**OXFORDSHIRE COUNTY COUNCIL’S RESPONSE TO CONSULTATION
ON THE FOLLOWING DEVELOPMENT PROPOSAL**

Application no: 21/04171/F

Proposal: Re-development of part of existing car park to provide a drive-thru cafe within Use Class E; together with associated car parking, servicing and access; landscaping and all associated works

Response date: 30th March 2022

Title:
Drainage Layout

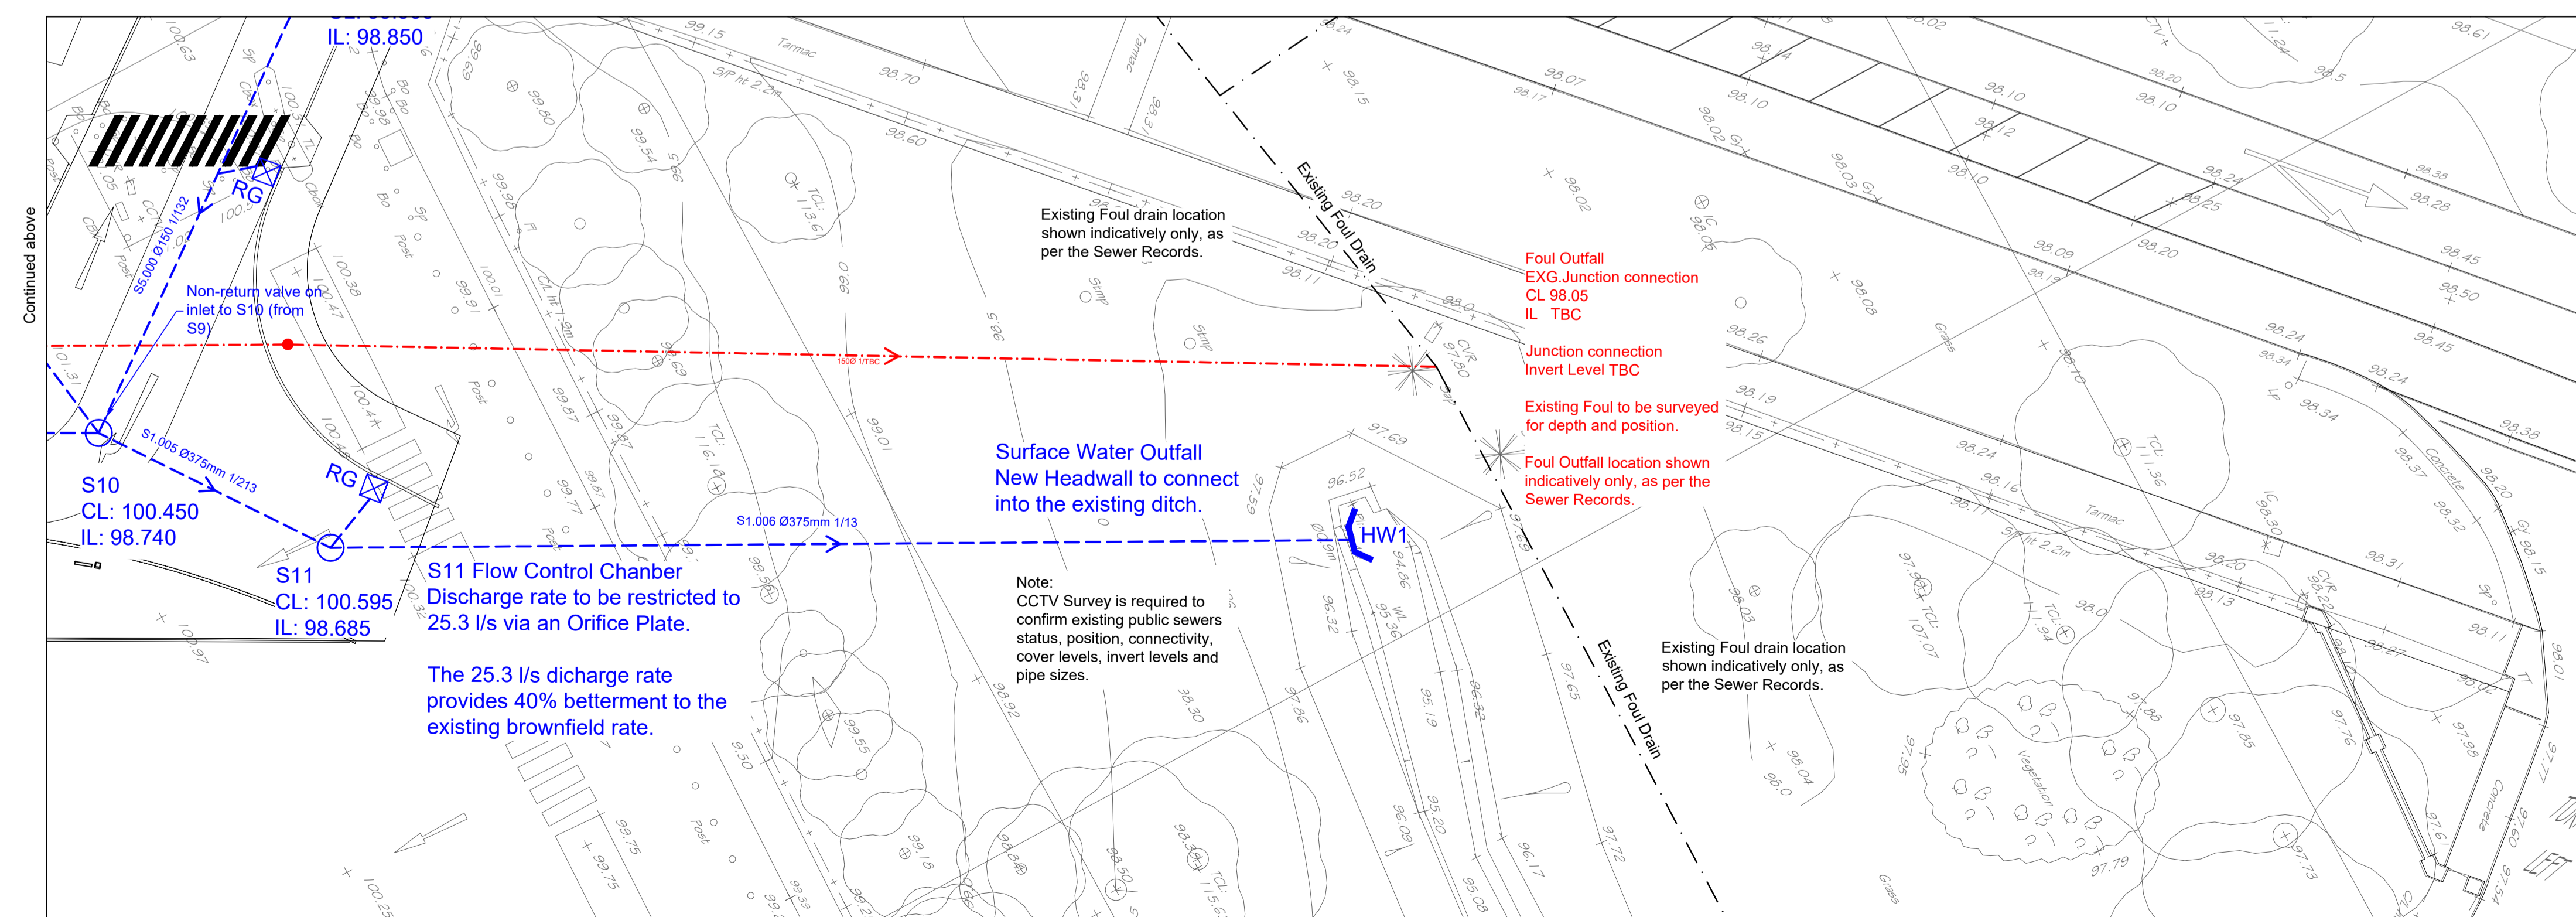
- Storage volume to be provided for the permeable paving on the drainage strategy plan and specifying the sub base depth.
- Calculations does not include all sections of permeable paving.
- Surface water flood exceedance plan to include proposed levels.

The drainage strategy drawing should include the storage volumes of each permeable paving sections and its sub base depth. Which should correlate with the calculations.

The calculations does not include all permeable paving sections. Also some of the permeable paving extents are not linked to the correct manholes. For instance permeable paving is linked to manhole S5. Please review the model and ensure all SuDS have been modelled and linked to the correct drainage infrastructure.
